**KIRKLEES METROPOLITAN COUNCIL
INVESTMENT & REGENERATION SERVICE**

**DELEGATED DECISION TO DETERMINE APPLICATIONS FOR
CONSENT, AGREEMENT OR APPROVAL REQUIRED BY CONDITION**

Reference No:	2025/44/93299/E
Site Address:	Centre 27 Business Park, Bankwood Way, Birstall, Batley, WF17 9TB
Description:	Discharge of details reserved by condition 8 (drainage) on previous permission 2025/91401 for variation condition 2 (plans) on previous permission 2024/93522 for variation conditions 2, 7, 12, 13, 14, 15, 16, 20 on previous permission 2023/93781 for demolition of existing buildings and erection of coffee shop with drive thru facility; drive-thru restaurant (Class E and Sui Generis); flexible commercial unit (Class E (a) and/or Class E (b) and/or hot-foot takeaway Sui Generis use); formation of hard and soft landscaping works; modifications to access and associated works
Recommending Officer:	Nicole Helliwell

DECISION – APPROVE DISCHARGE OF CONDITION 8

PROPOSED SURFACE WATER DRAINAGE LAYOUT

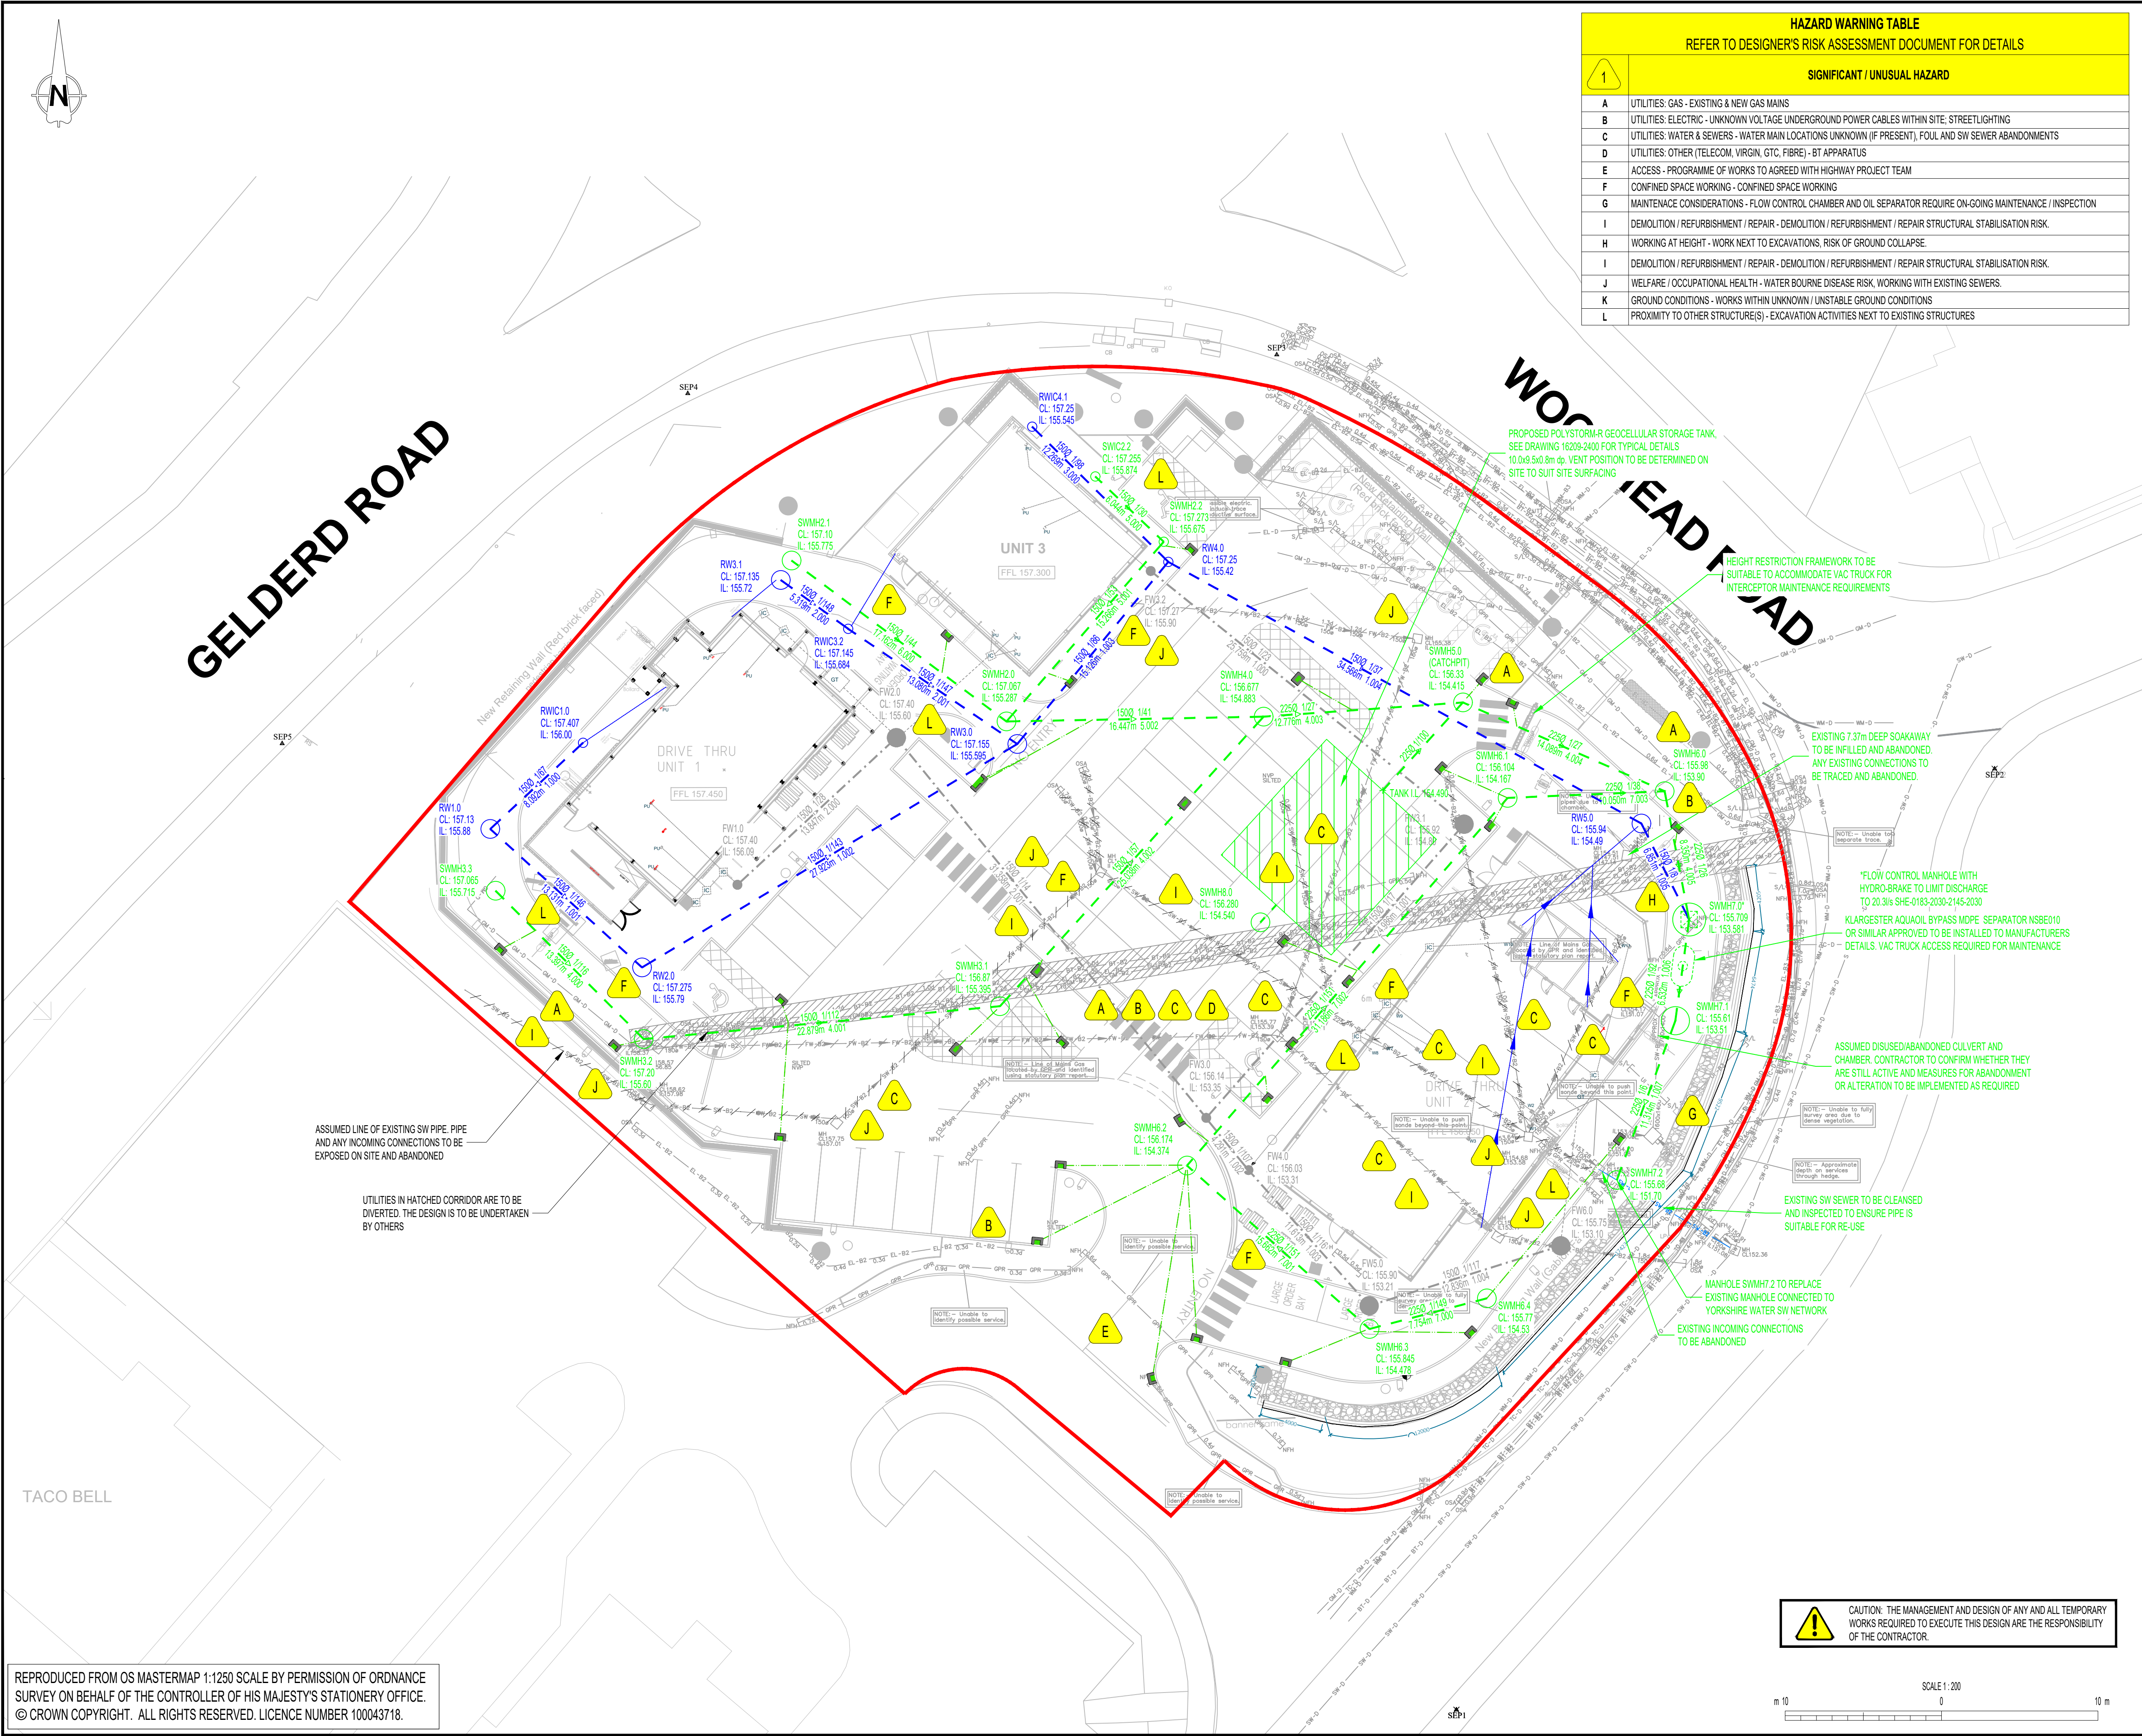
A 'Proposed Surface Water Drainage Layout' drawing (reference no. 16209-2000 revision T03, dated 14/06/2026*) (should be 14/01/2026) has been received in support of the Condition 8. SWMH08 has now been added to provide access into the attenuation tank and SWMH05 is noted as a catchpit and gradient/Invert Level of pipe through the attenuation tank now shown. These revisions are accepted by the LLFA, and therefore, Condition 8 will be

discharged by the provision of the approved drainage scheme prior to occupation of the development, and its retention thereafter.
